**25358 Land at Albany Drive, Copster Green, Ribble Valley, BB1 9ET**

**Issue 03 (08/06/2026)**

**Surface Water Drainage Assessment – Supporting Clarification**

Impermeable Area & Flood Route Plan

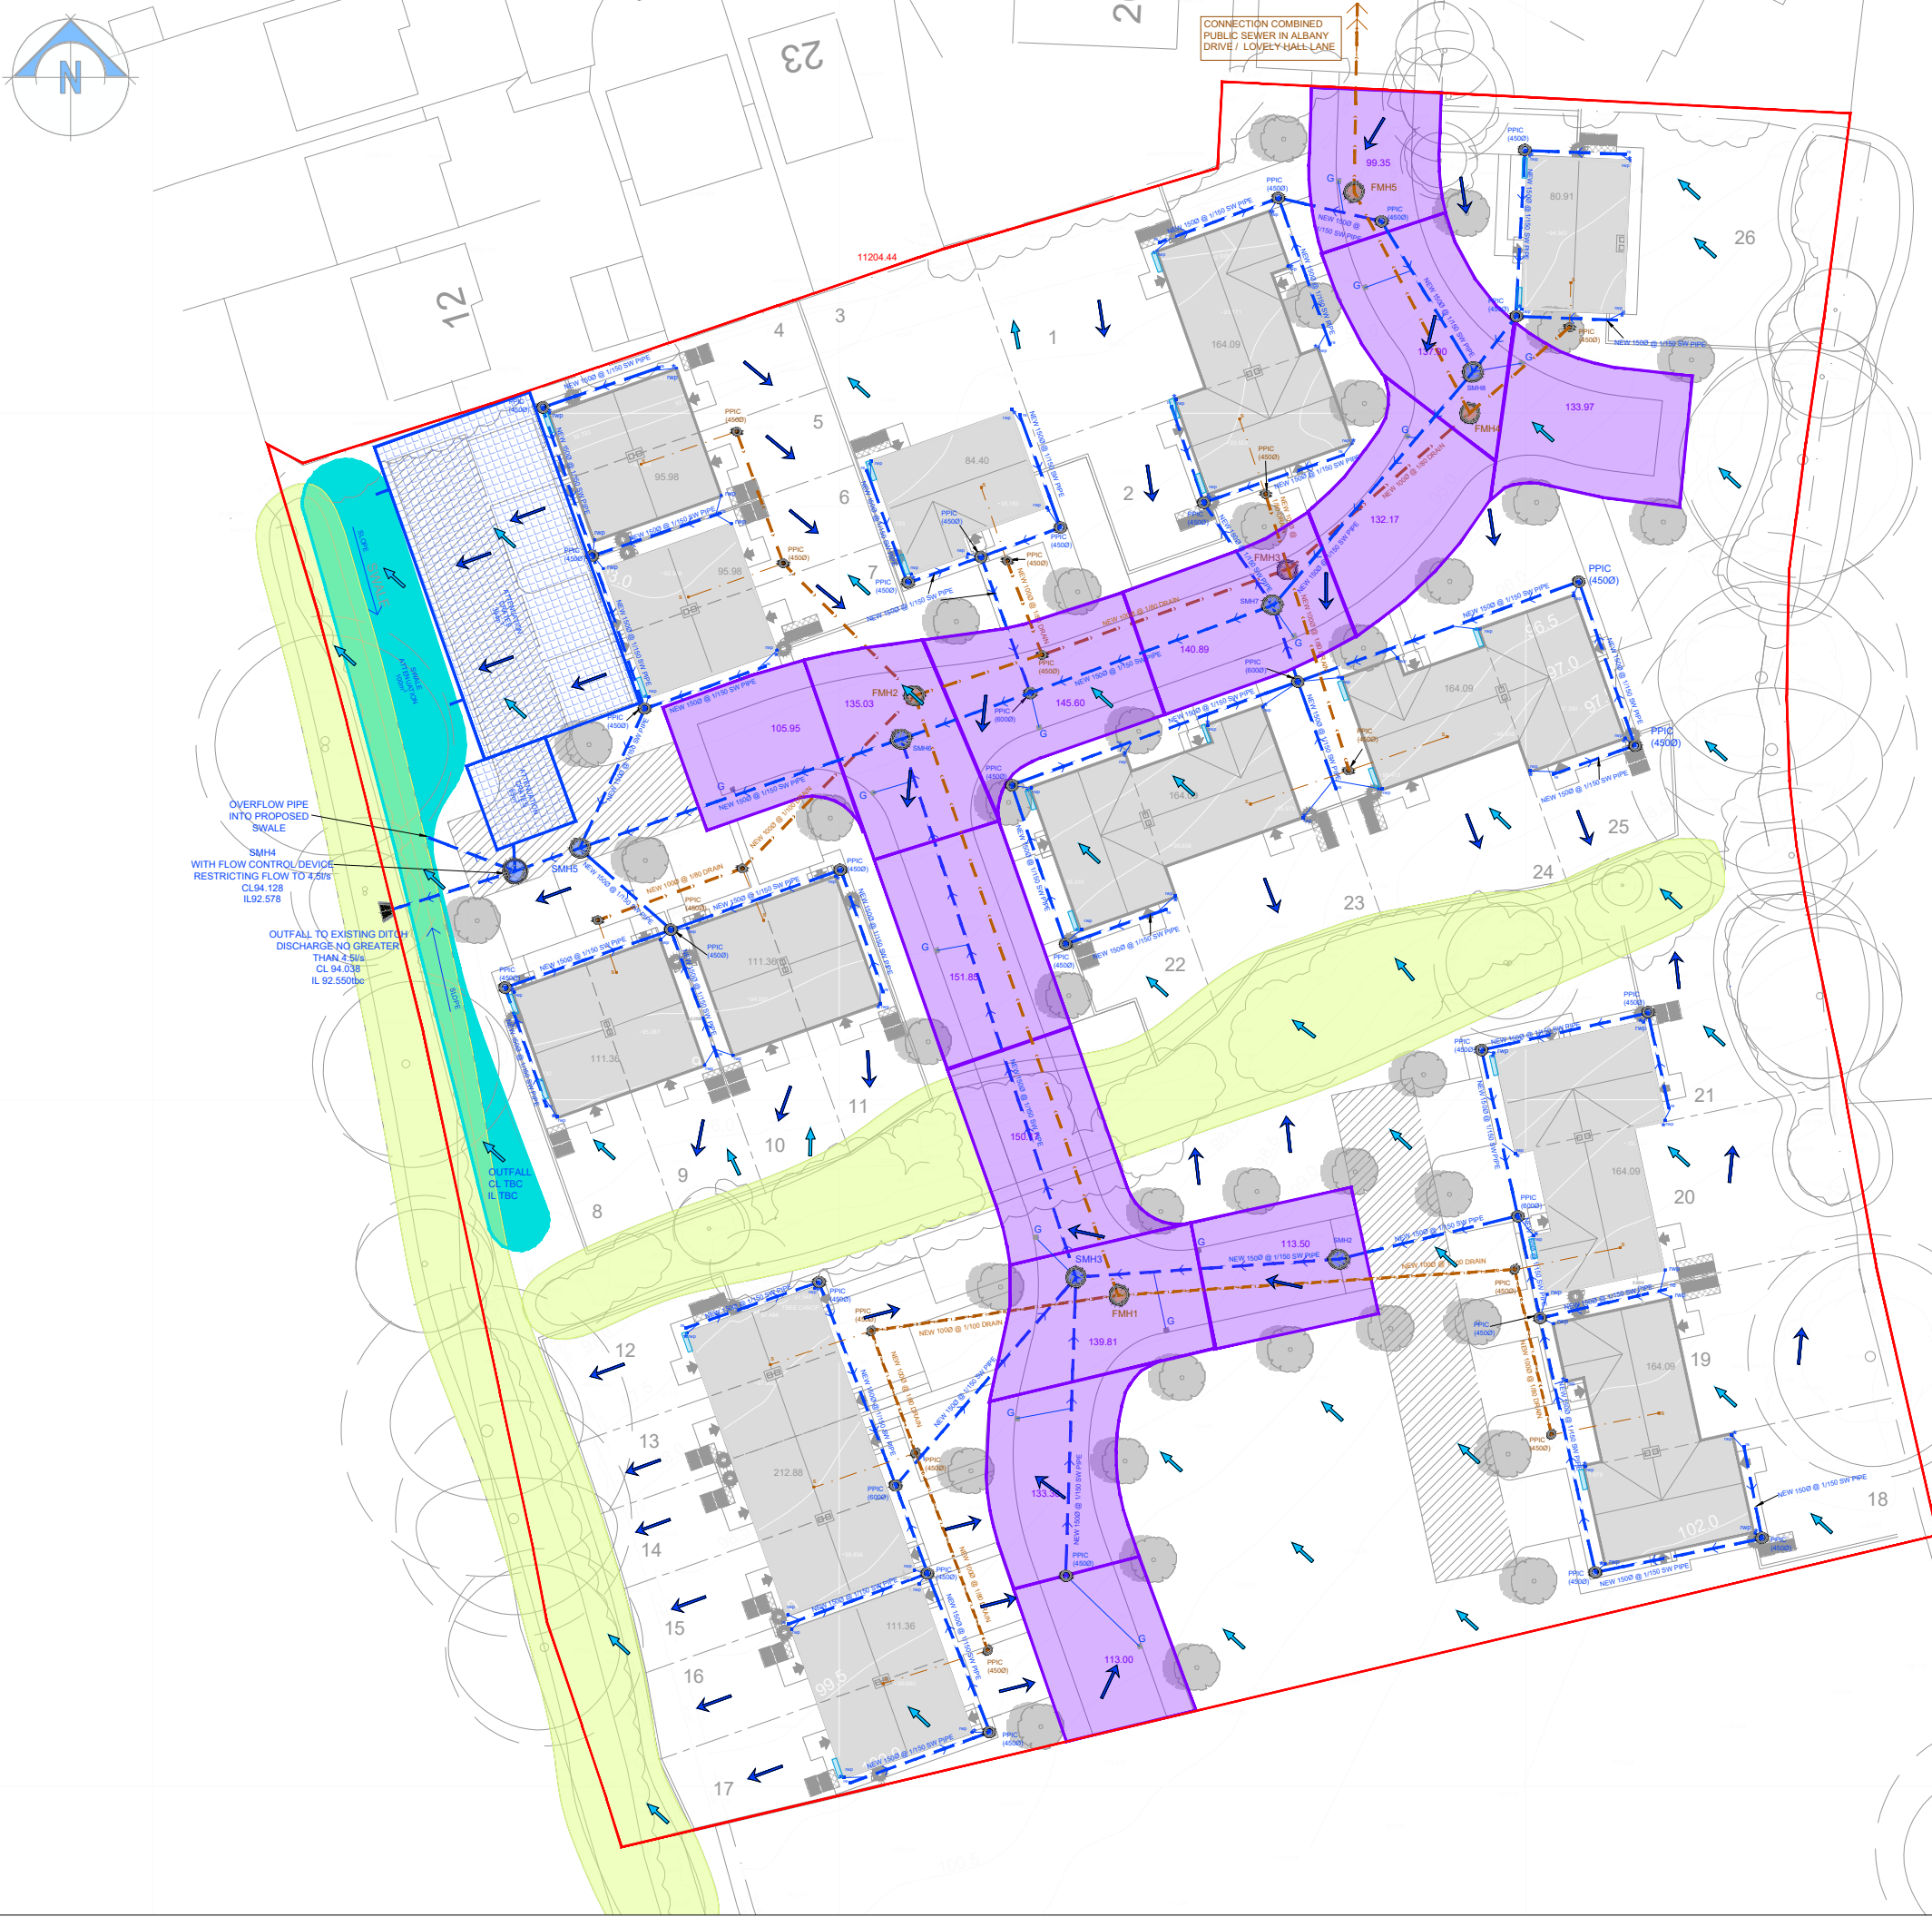
- the methodology adopted for determining the greenfield runoff rate;
- the contributing catchment area used within the post-development attenuation calculations; and
- demonstration that the proposed discharge rate and runoff volume control accord with the updated SuDS standards.

- the equivalent greenfield runoff rate derived from the full undeveloped red line boundary area (1.120 ha);
- the proposed restricted discharge rate based on the 1 in 2-year (50% AEP) greenfield runoff rate;
- compliance with the minimum allowable discharge criteria of 3 l/s/ha; and
- the attenuation storage requirements associated with the positively drained post-development catchment entering the proposed surface water drainage system.

The proposed surface water drainage strategy restricts discharge to 9.0 l/s via a hydrobrake flow control device, with attenuation provided through a combination of permeable paving, geocellular storage crates and swale storage prior to discharge to the existing western boundary ditch/watercourse.
